FW: P/5/26/PL

'1 No 4-bed chalet bungalow, alteration of existing bungalow to include off-street parking and rear dormer extension (resubmission following P/118/25/PL). This application is in CIL Zone 4 and is CIL Liable as a new dwelling.'

Proposed Roof Plan 44A

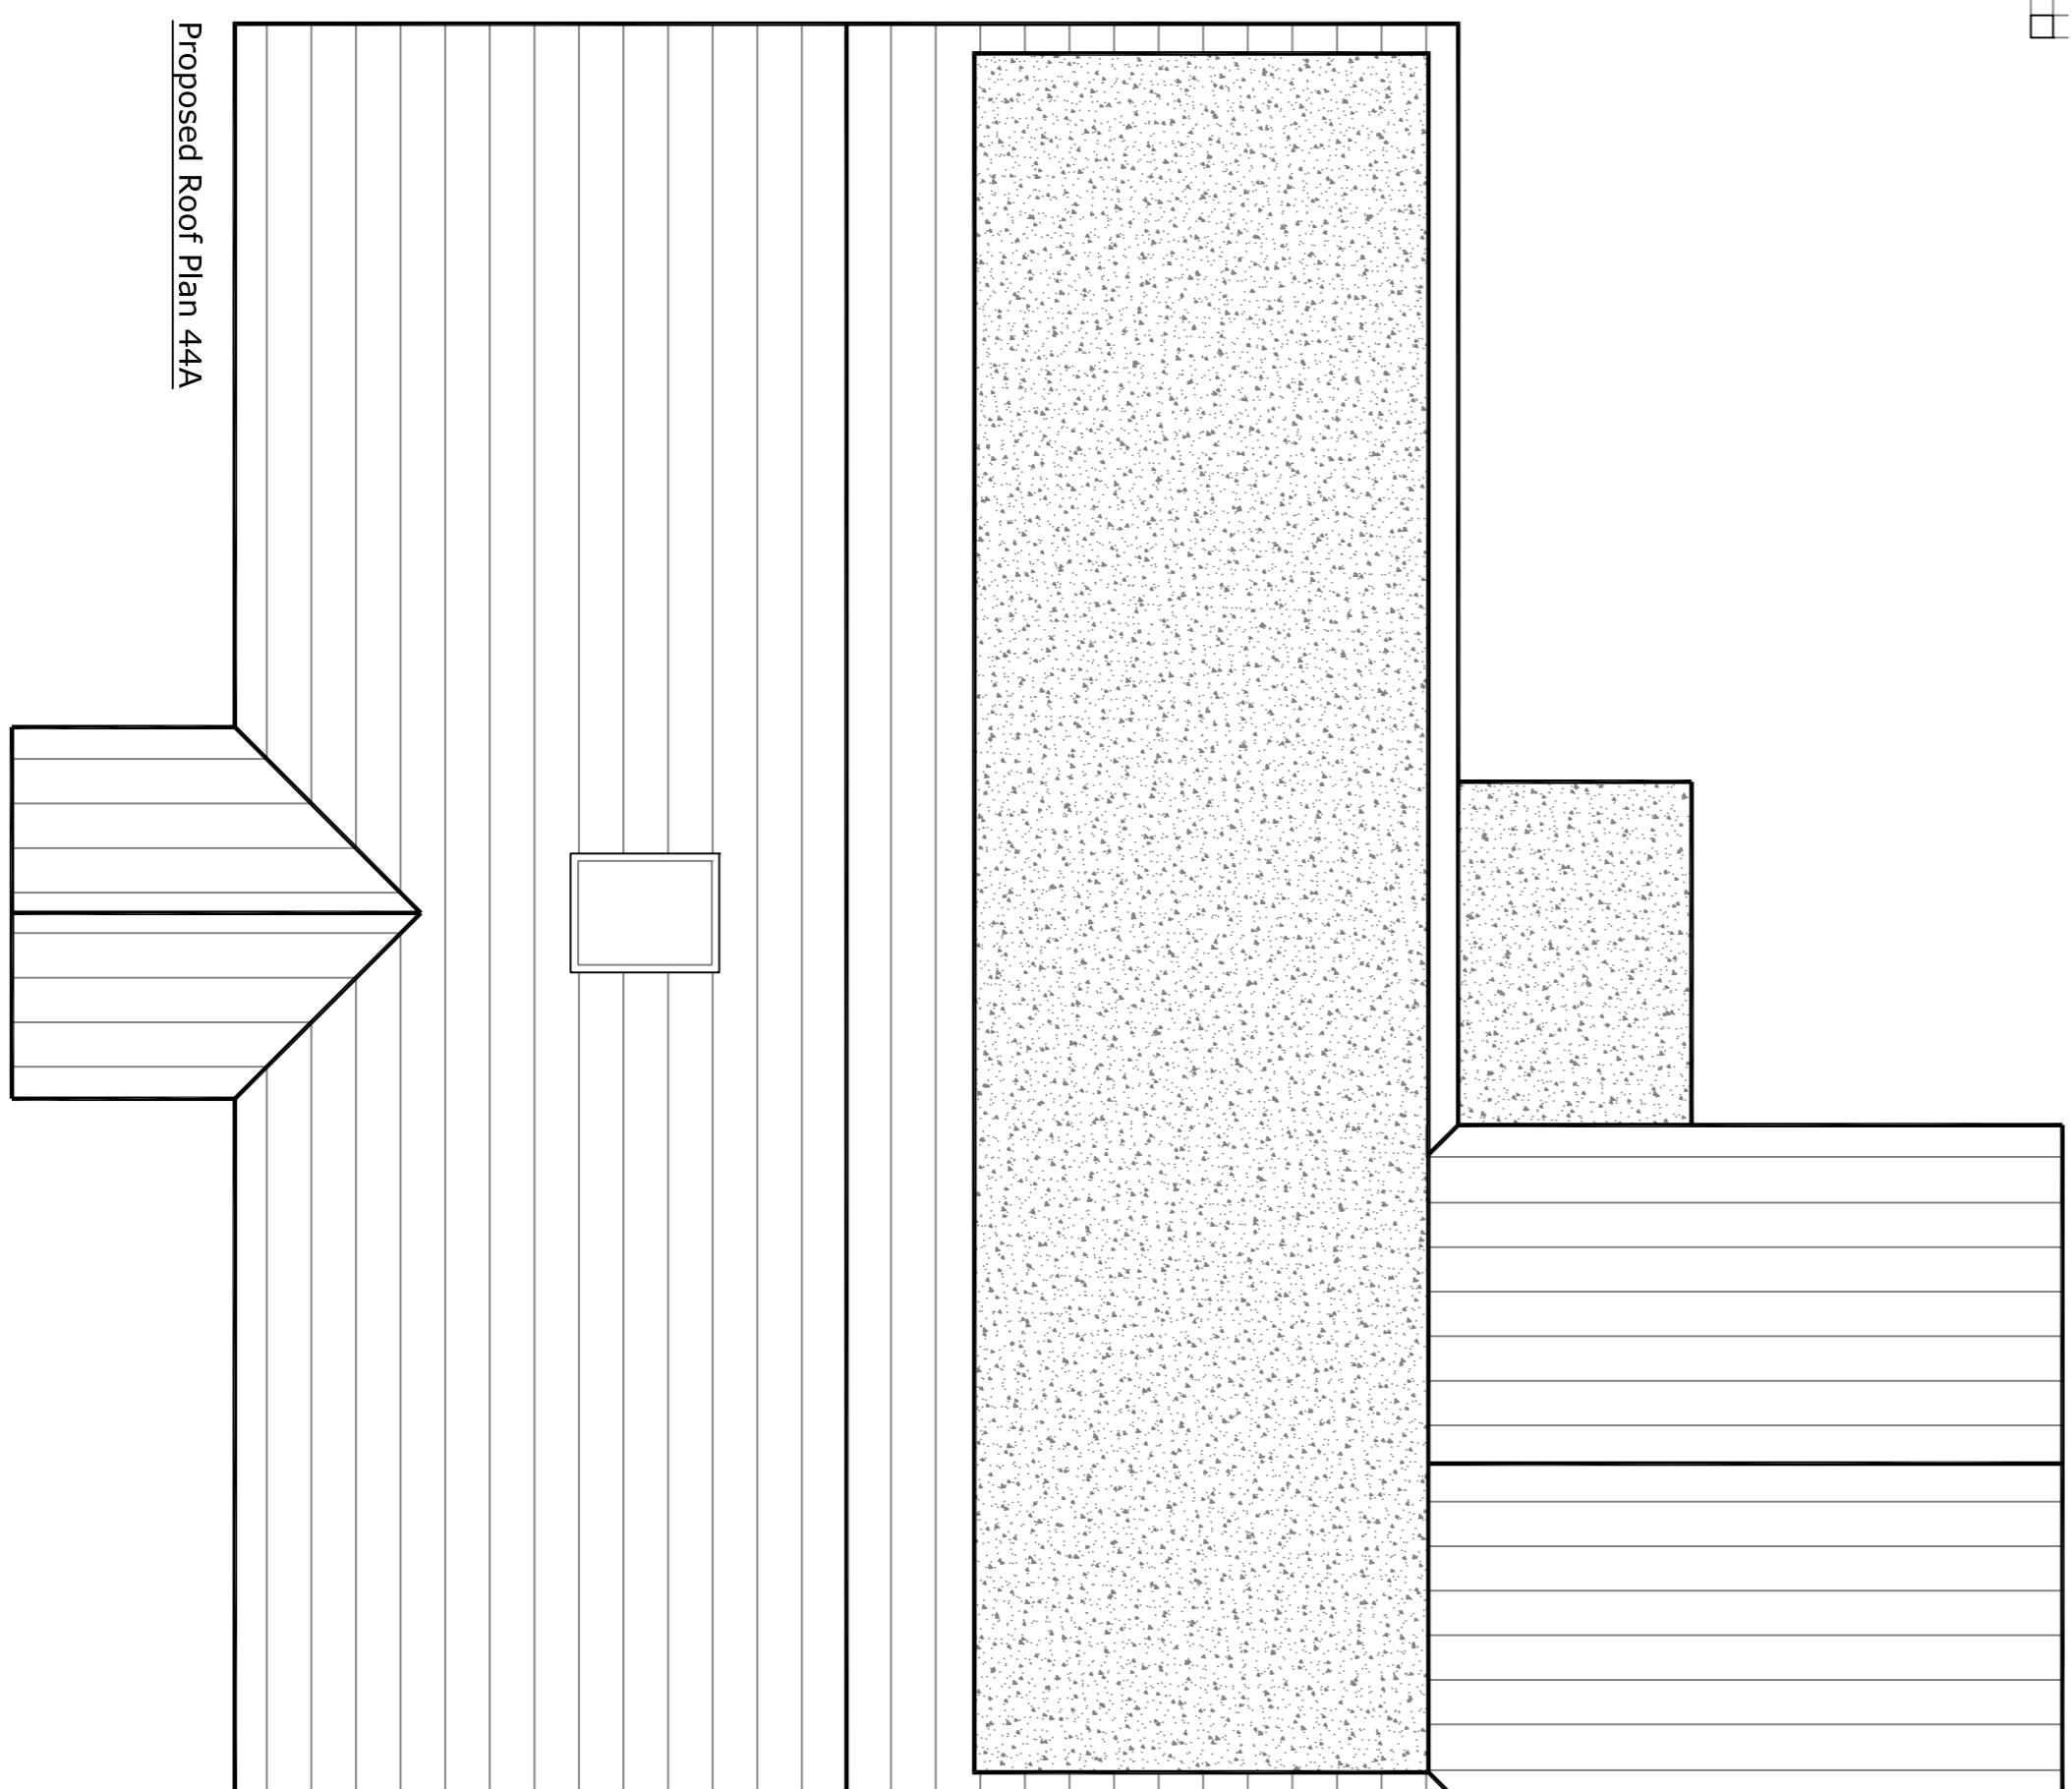
Following review, could I request that the rear dormers of both dwellings are reduced in width, perhaps at least by 0.5m each side, and that they are set back into the roof slope slightly further by perhaps a couple of rows of tiles. Our aim is to reduce their dominance of the rear roof slopes.

Could I also request that the northernmost first-floor rear window within the dormer of No. 44A be reduced to a two-pane casement? With the new design and relocation of the single-storey component, there is a greater perceived and actual overlooking impact of No. 2 Sea Way. The aim of this is to reduce how imposing this viewpoint may feel within the eastern end of No.2's plot, acknowledging that the eastern end of that plot is not the primary amenity space, but still remains of amenity value to the property.

Thanks for your email, please see attached amended plans, I think I have covered everything you needed but if I have missed something please let me know and I will change. Am I correct in thinking that this application is now looking more favourable than the last? Thanks
